From: [REDACTED]
Sent: 26 April 2022 12:12
To: Planning
Subject: 3/2022/0082 - BB7 3BB

WITHDRAWAL OF NOTICE

OBJECTION

Client	The Duchy of Lancaster		
Contract	OLD GARAGE SITE Dunsop Bridge		
Drawing title	PROPOSED SITE PLAN & BLOCK PLAN		
Scale	Job No.	Dwg No.	
1:250	KL2887	105	B

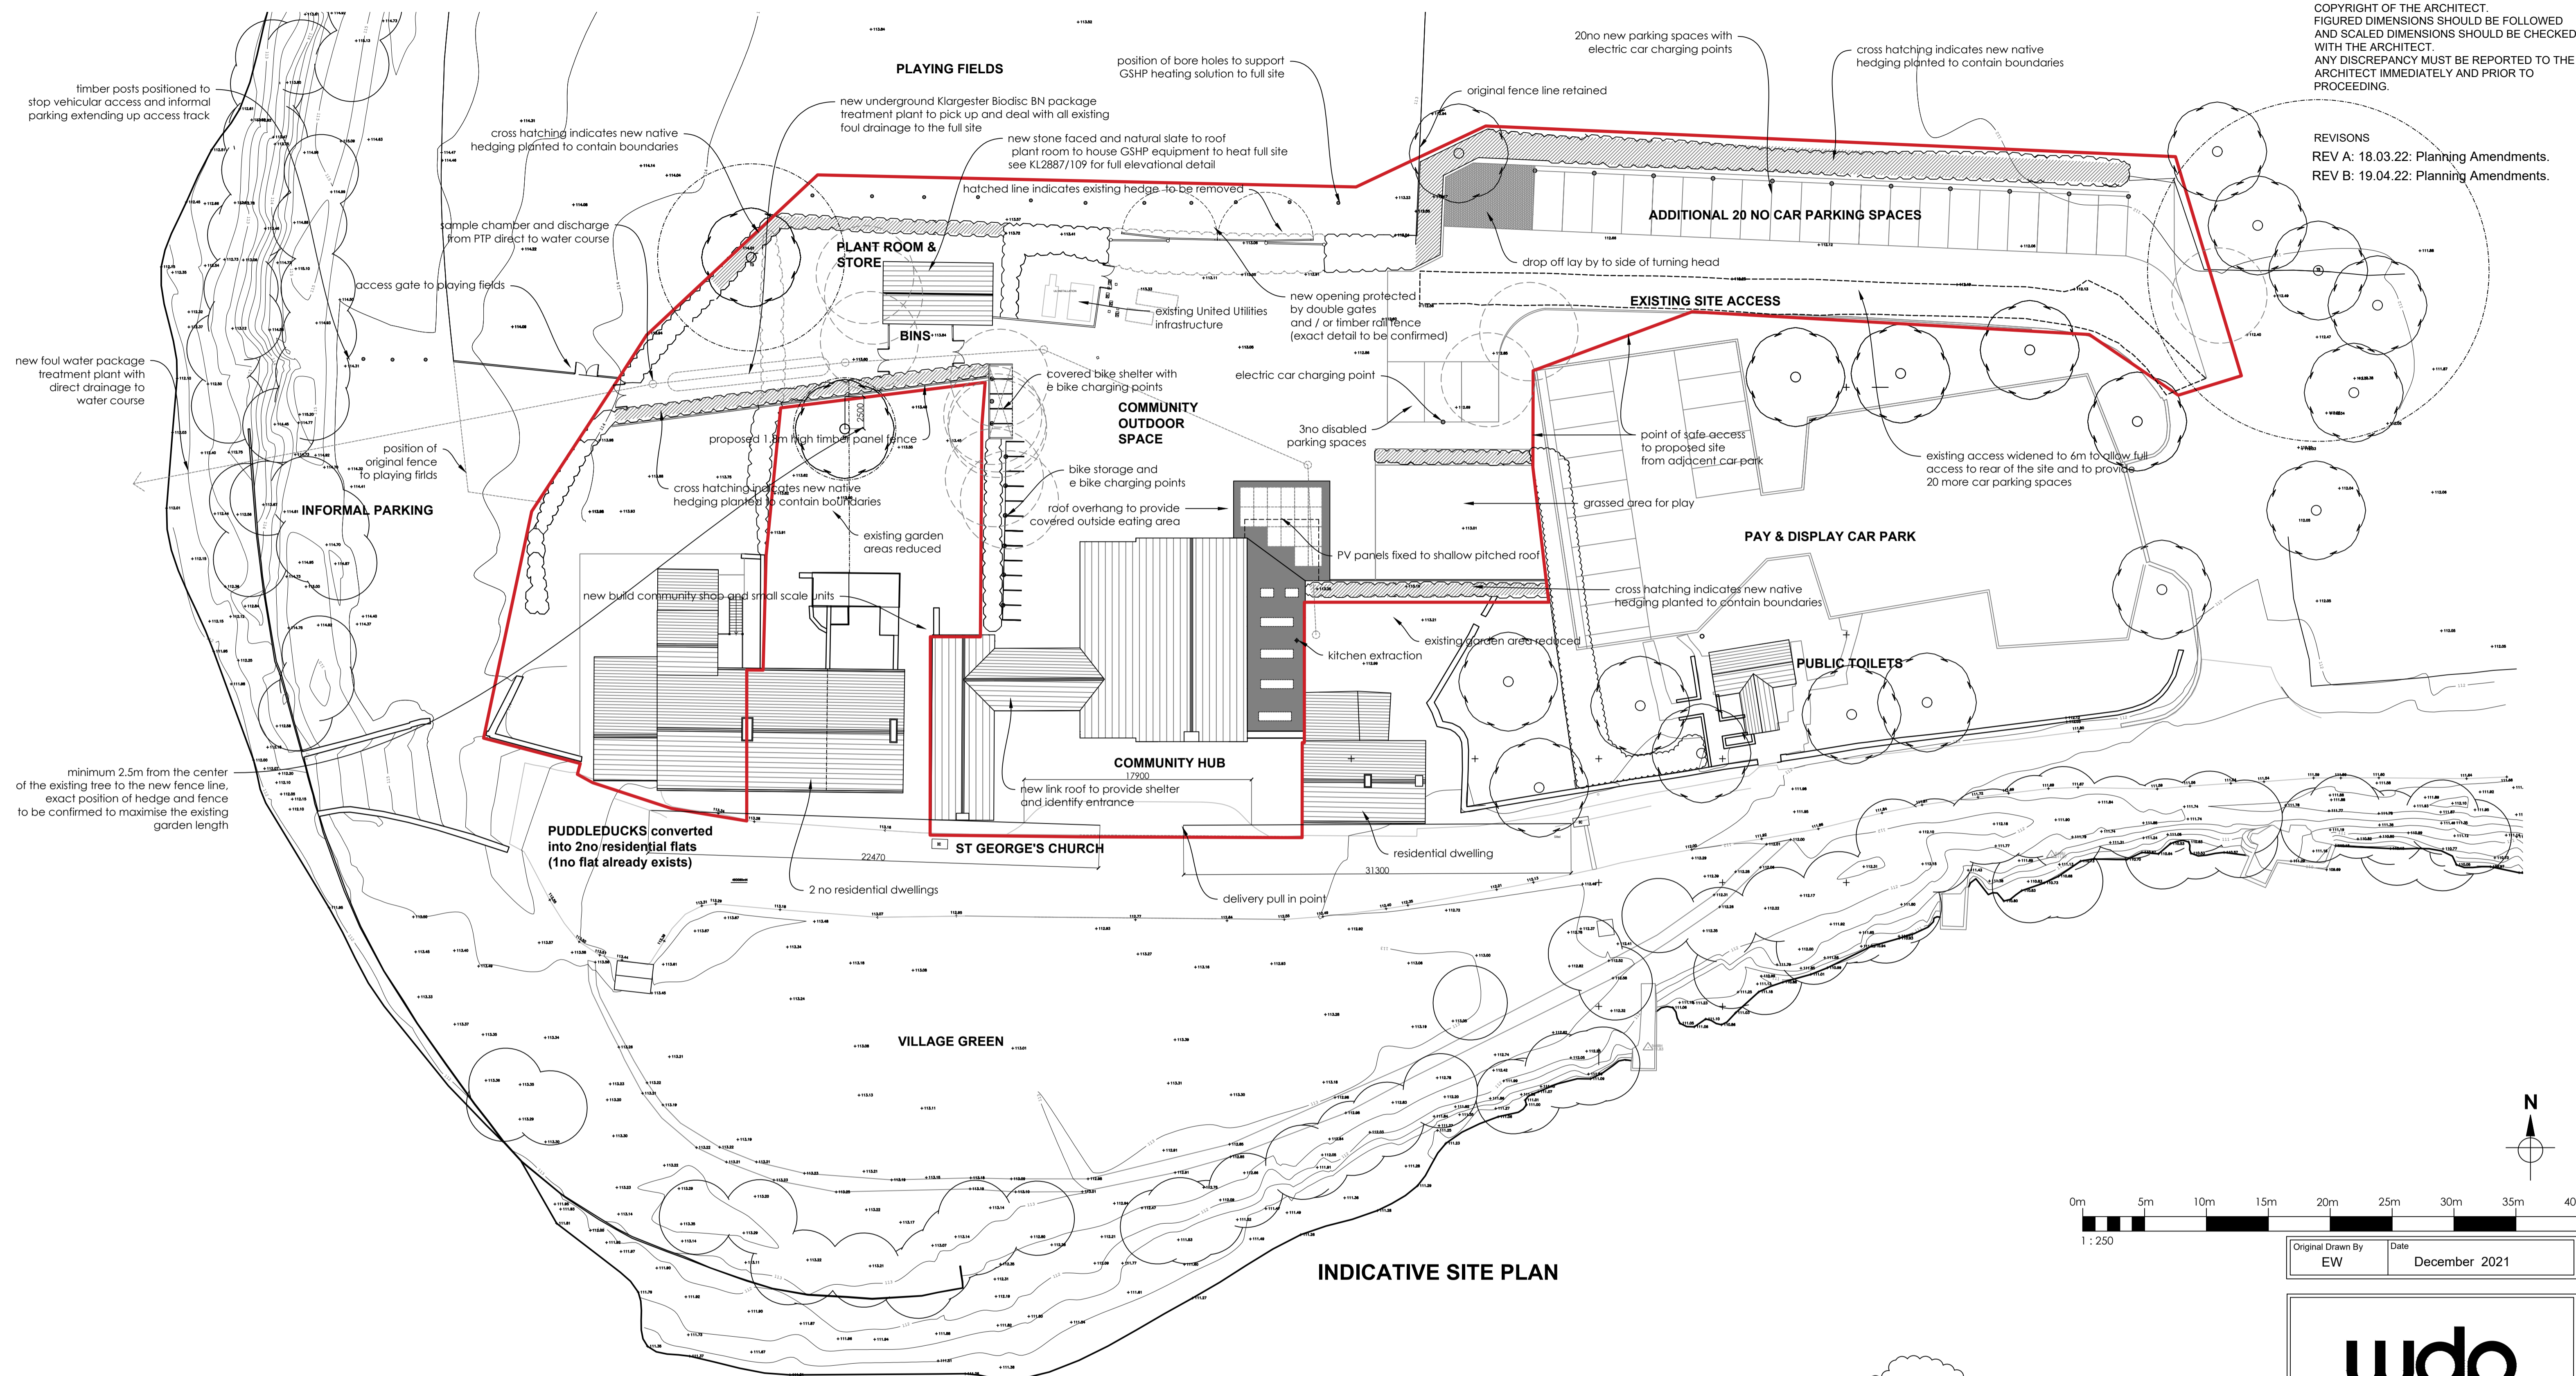
Please note following the visit [REDACTED] by the Planning Officer who kindly noted my specific concerns regarding one aspect of the the Application - the installation of a footpath [REDACTED]
[REDACTED]

These minor changes relate to an agreed minimum distance from a preserved Copper Beech tree to the "start line" of the footpath development of 2.5m. There is agreement also that the border between [REDACTED] and the footpath shall be protected by the erection of a solid wooden fence 1.8m high [REDACTED]
[REDACTED] These arrangements are satisfactory and negate the need for my Objection and personal appearance at the Hearing.
